**Ref No:** F2020/00663

Application No: SSD-10831778

**Re: Randwick City Council submission on the State Significant Development SSD-10831778 – Sydney Children’s Hospital Stage 1 and Children’s Comprehensive Campus Centre (SSD-10831778)**

SITE PLAN - SOLAR STUDY
SHEET 03

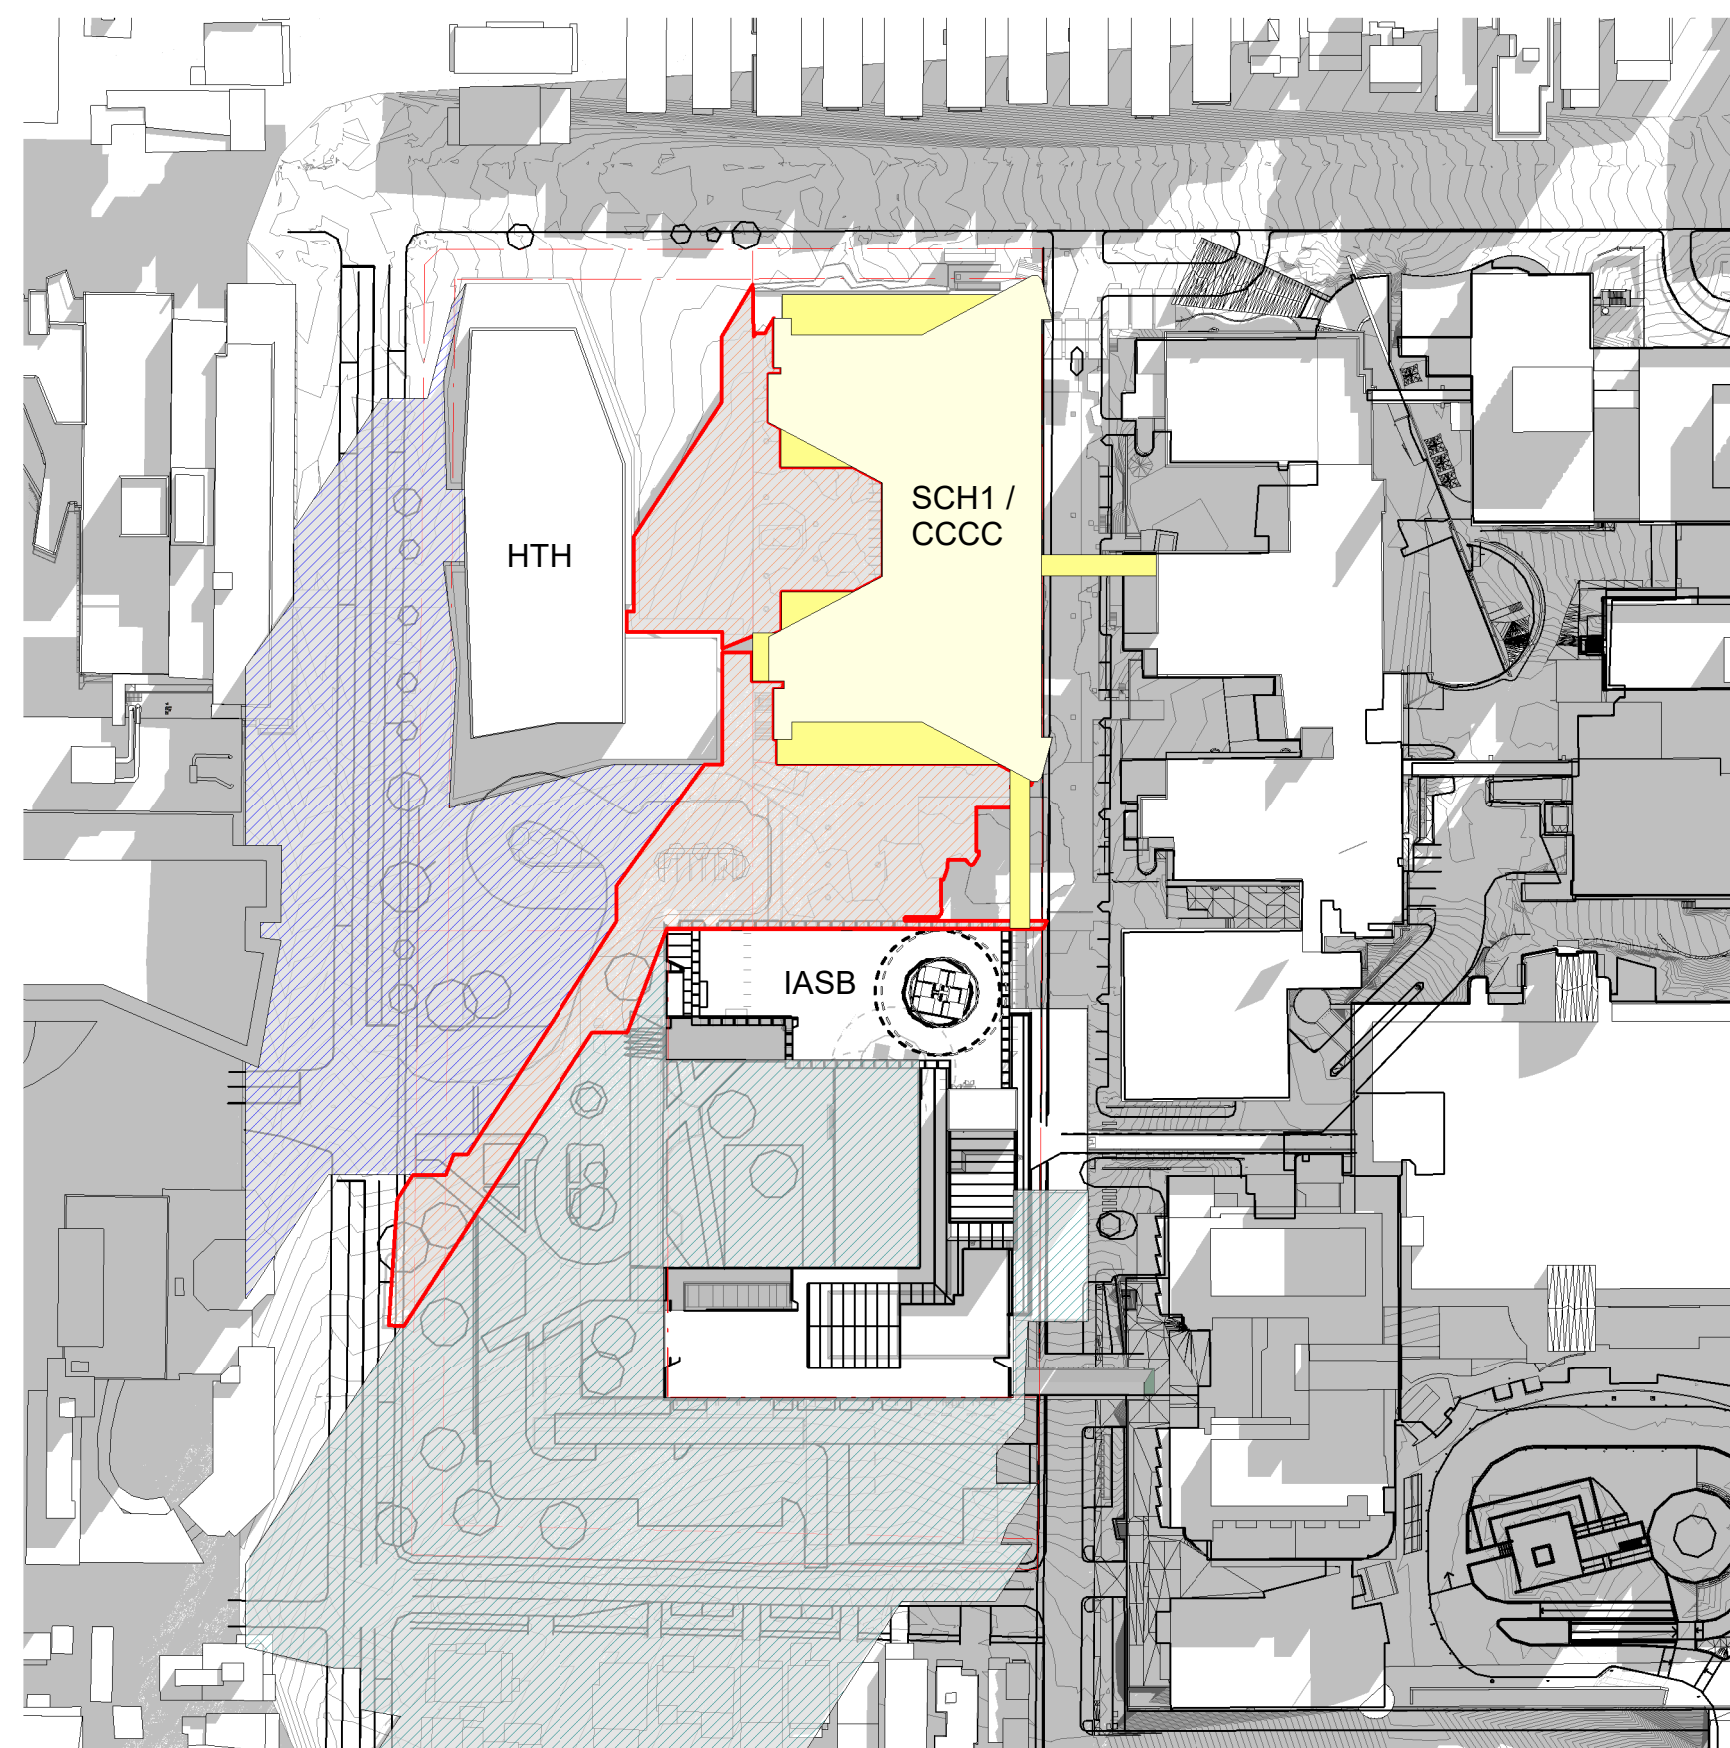
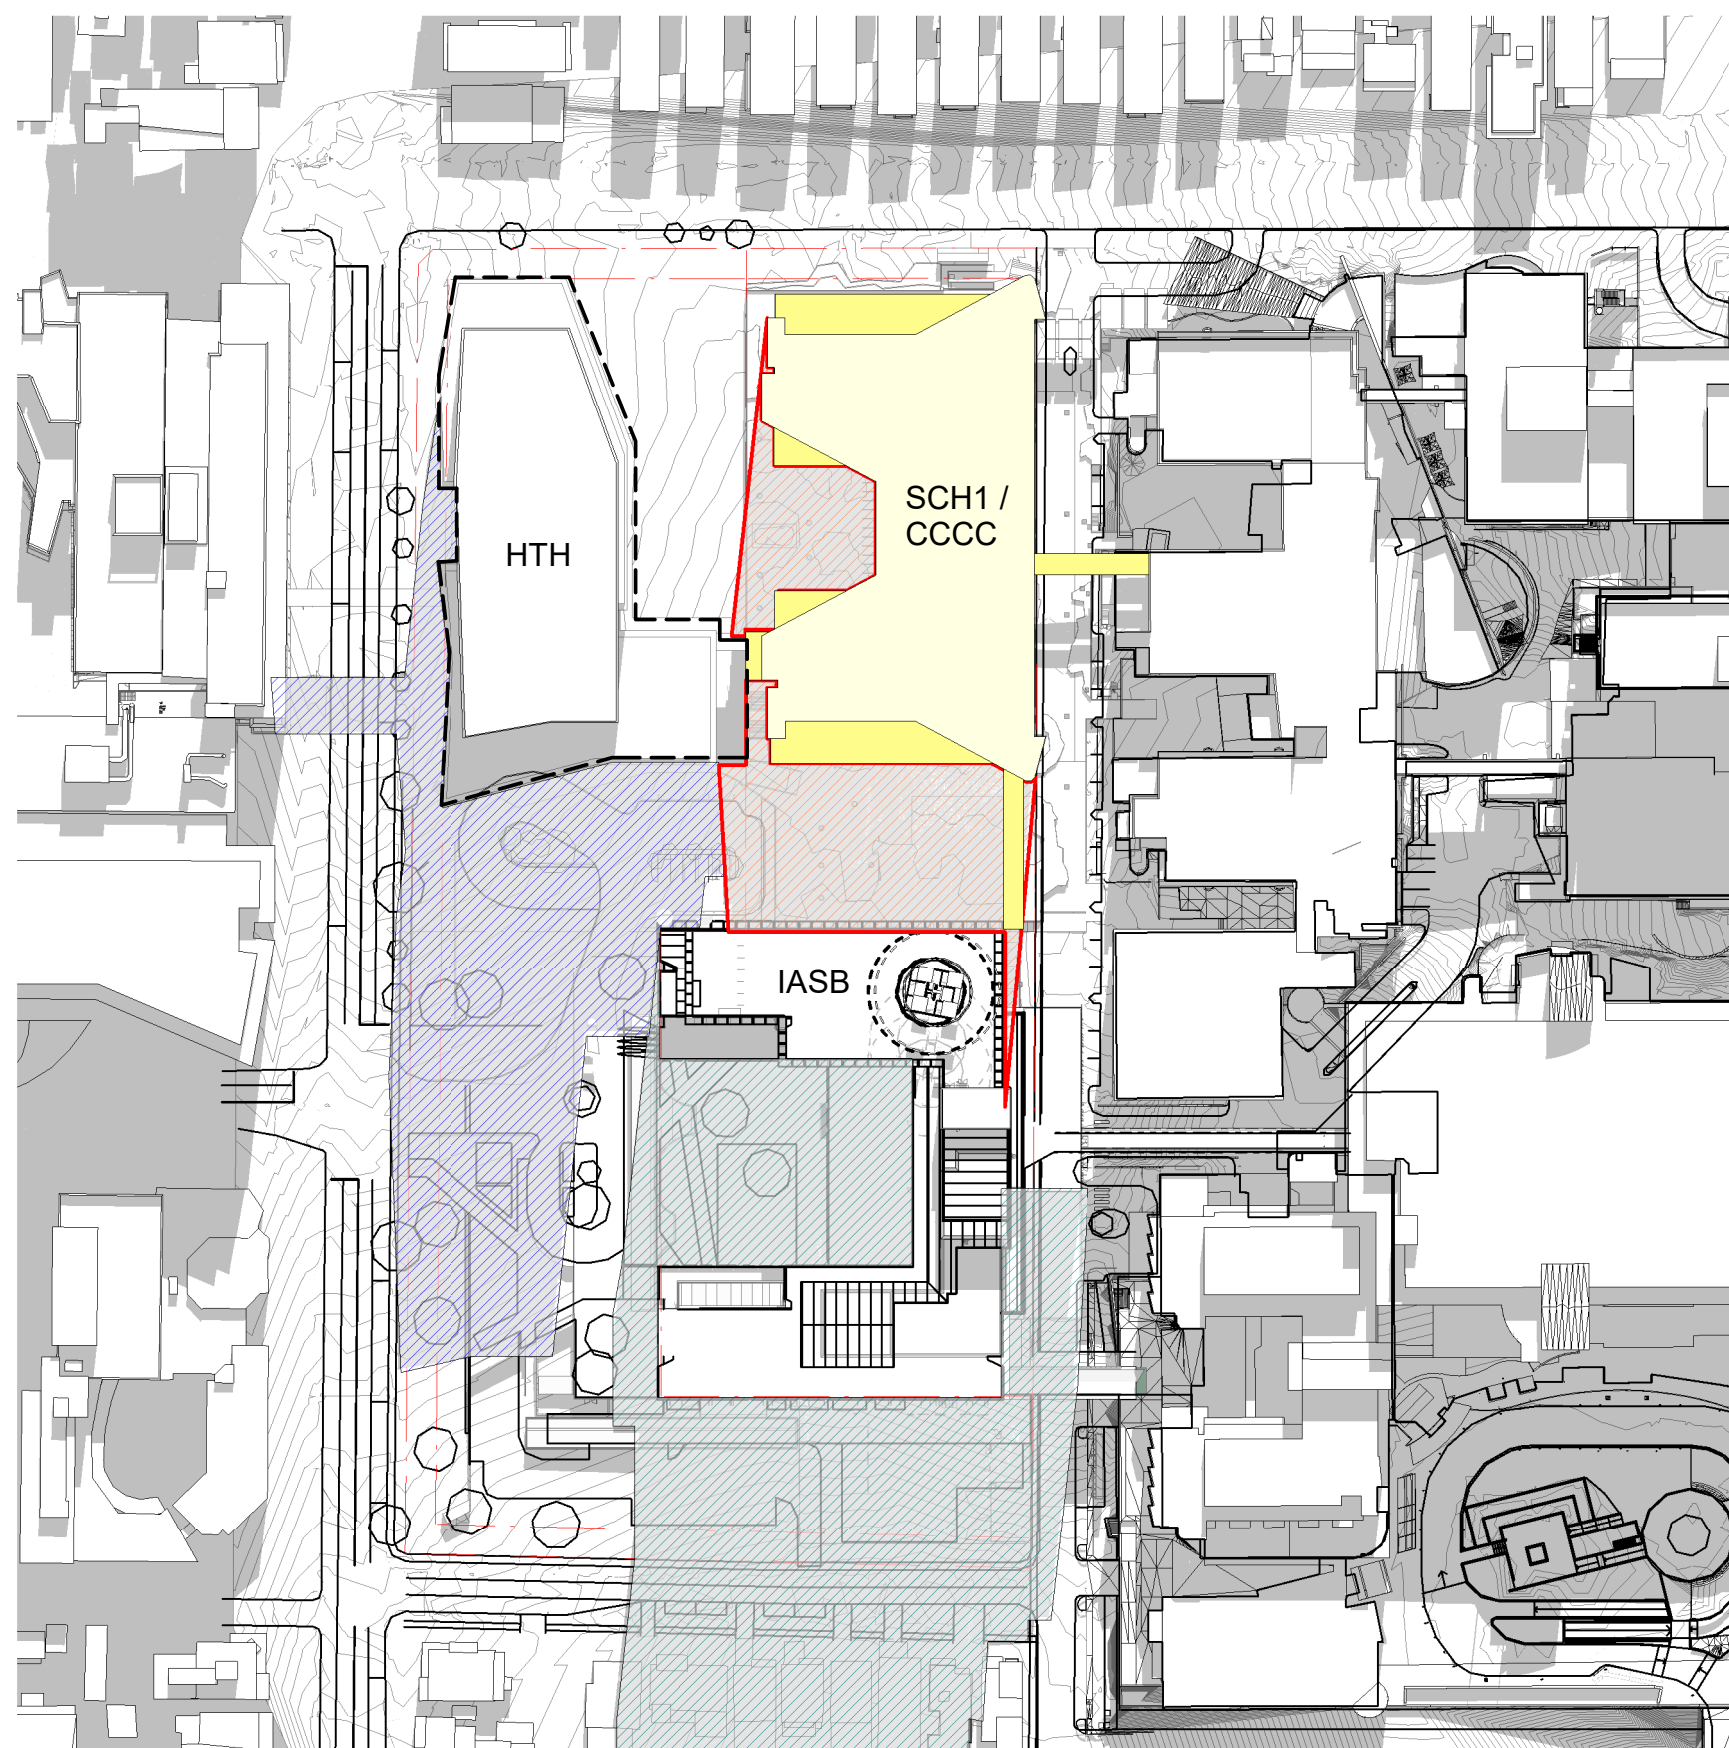
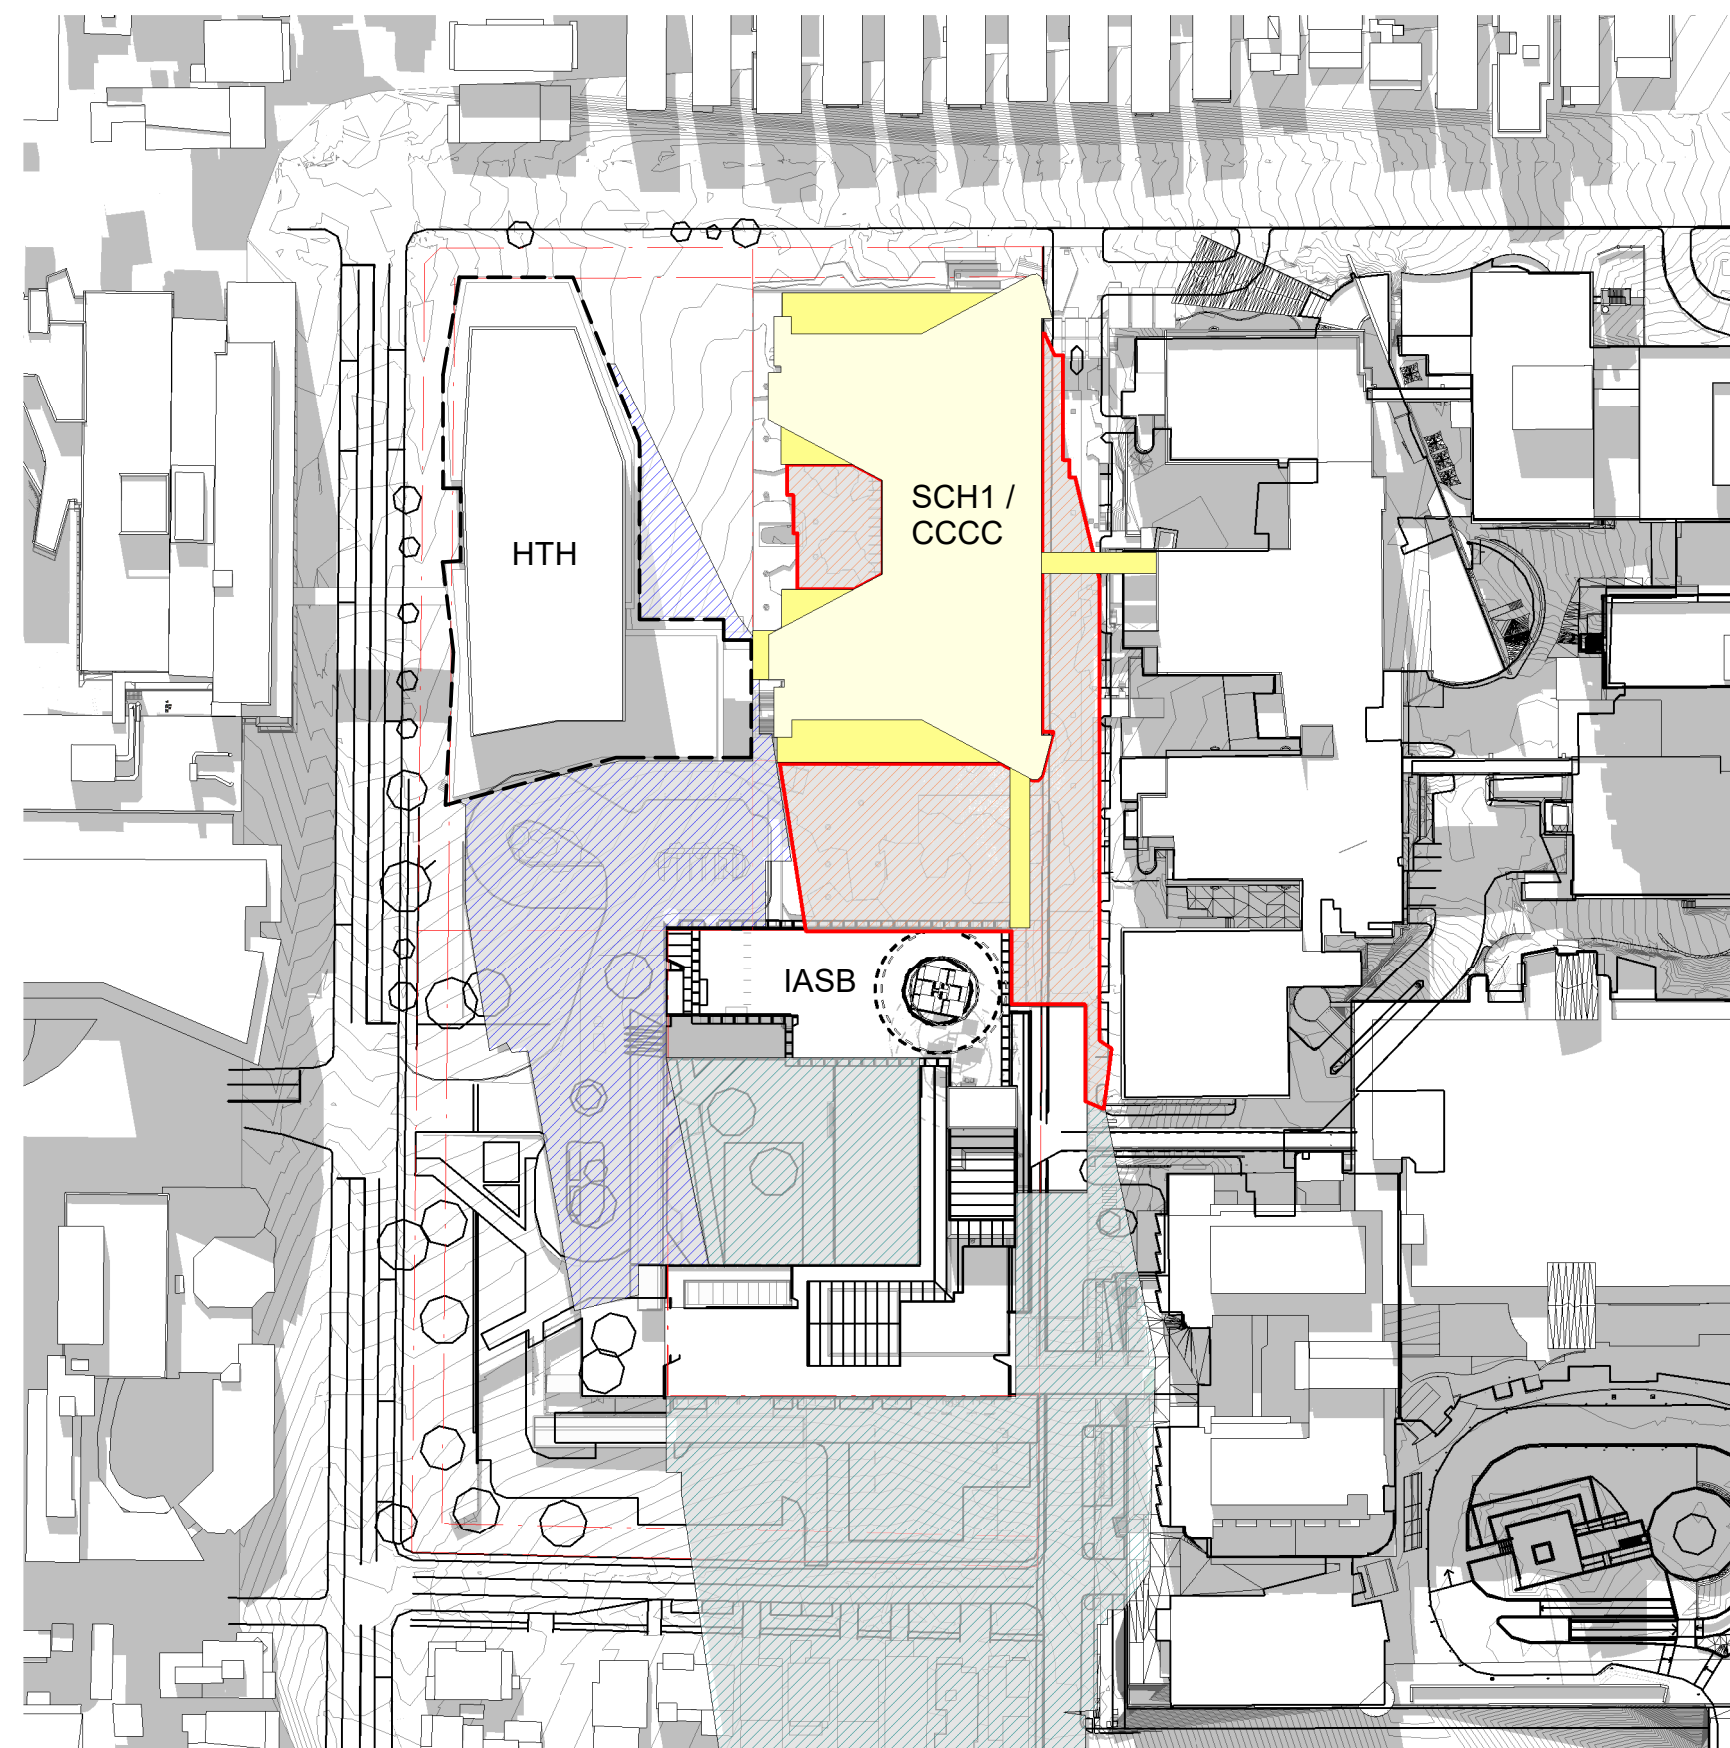
33. Shadow studies should be provided at hourly intervals for the winter solstice to assess solar access to the key public domain areas such as the plaza and children's play area.
